Deadline 6 response

Examination question Q2.14.8

Dafydd Griffiths on behalf of the NACP

Figure 5-3 Public access and recreational facilities during Site Preparation and Clearance

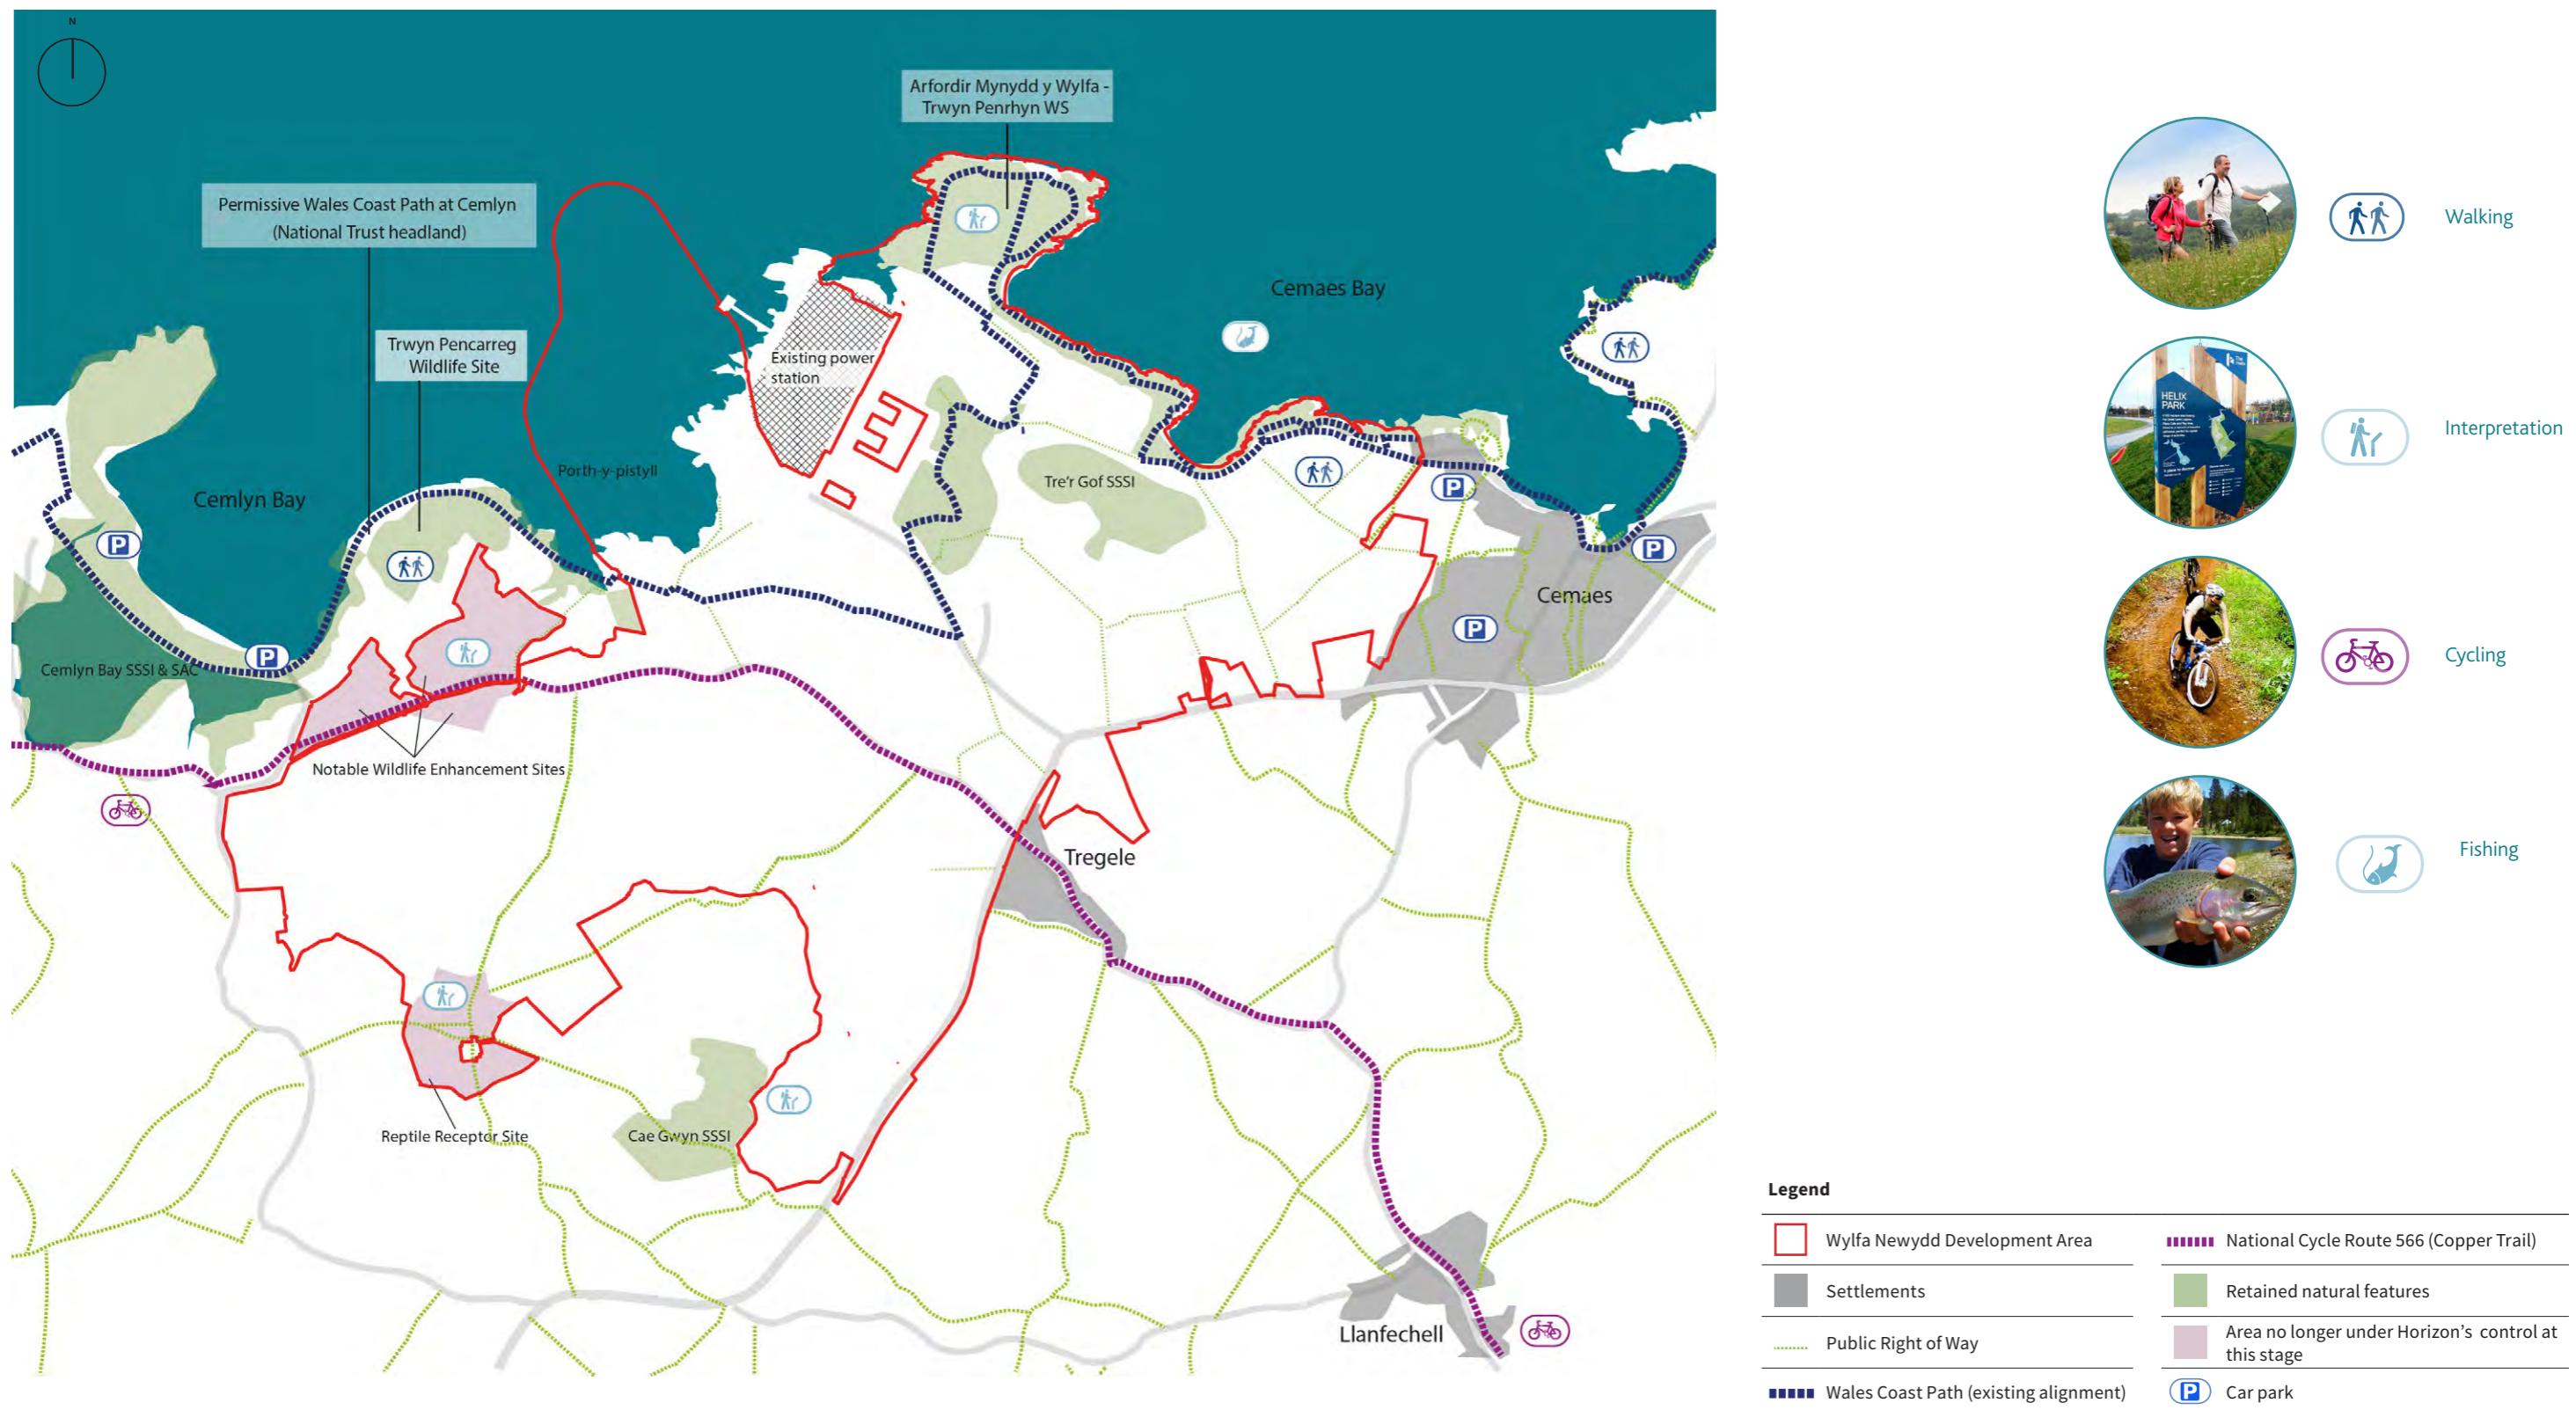
During the construction phase the NACP do not consider the option selected to be the best diversion in the circumstances and do not agree with the applicant's justification. Whilst the current proposal does involve the shortest riding distance alongside the A5025 it does not encourage stops at Tregele or visits to Cemaes as they will no longer be on, or as close to, the route. This is a major drawback of the option selected by the applicant. The NACP have previously noted, at deadline 2, deadline 4 and during the accompanied site visit, concerns about the sight lines, the speed and make up of traffic at the proposed crossing at the Bwlch junction particularly for cyclists following the route in a clockwise direction.

On balance, the NACP view is that the other shortlisted option is more appropriate and safer. Cyclists could use a shared use path from Nanner Road to the Wylfa Newydd roundabout. Crossing at the roundabout would be a lane at a time and the vehicles would be moving much slower than at the Bwlch crossing. Only traffic entering or leaving the WNDA would have to be considered. From the roundabout to Tregele the upgraded shared use path could be used and the original Tregele crossing point navigated. The NACP are not unduly concerned about the small increase in length of the route via Tregele. The Copper Trail is a circuitous route.

The NACP do not agree with the applicant's assertion that a single diversion during both construction and operation is preferable to avoid confusing cyclists! The construction phase is estimated at around 10 years and operation at least 60 years. With these timescales the route selected should be the one that will encourage cycling for recreation and Active Travel and the applicant has a role to play in this.
